Harnett County Government Complex
307 Cornelius Harnett Boulevard
Lillington, NC 27546

Re: Status of Improvement Permit Application HTE # 11-5-26393

An attempt was made to evaluate your property for the purpose of issuing an Improvement Permit. The evaluation could not be completed for one or more of the following reasons.

# Plot Plan

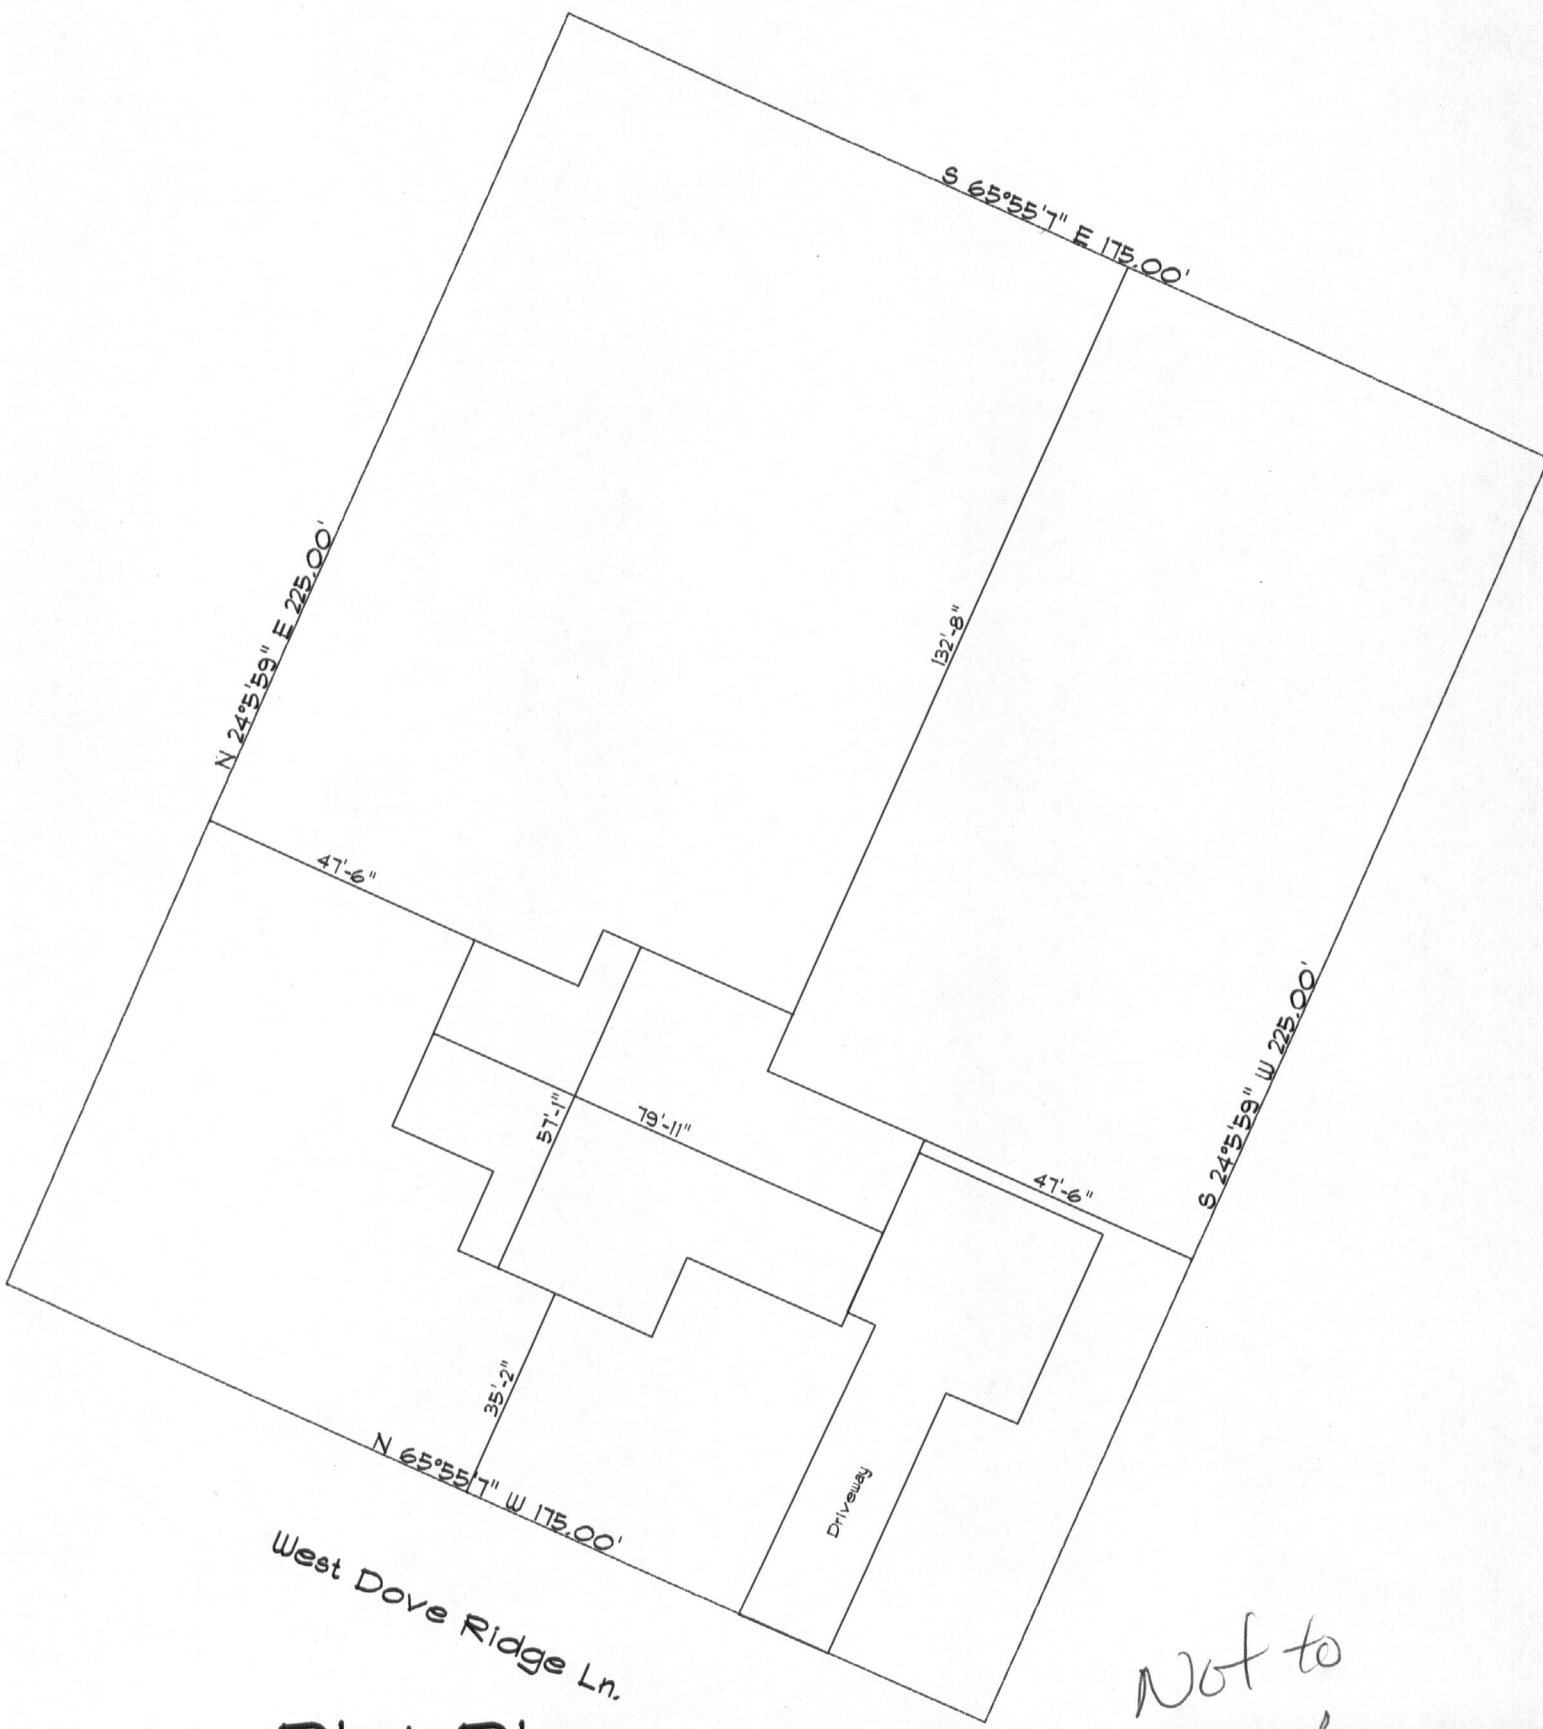
- 1. Use pink flags to mark property lines. All irons that are set by surveyor need to be visible. (*\$25.00 fee incurred*)
- 2. Use orange flags to mark house corners. Did not match site plan (*\$25.00 fee incurred*)
- 3. Directions not clear to property (*\$25.00 fee incurred*)
- 4. Property needs only brush or vegetation removed
- 5. Backhoe pits required
- 6. Other-
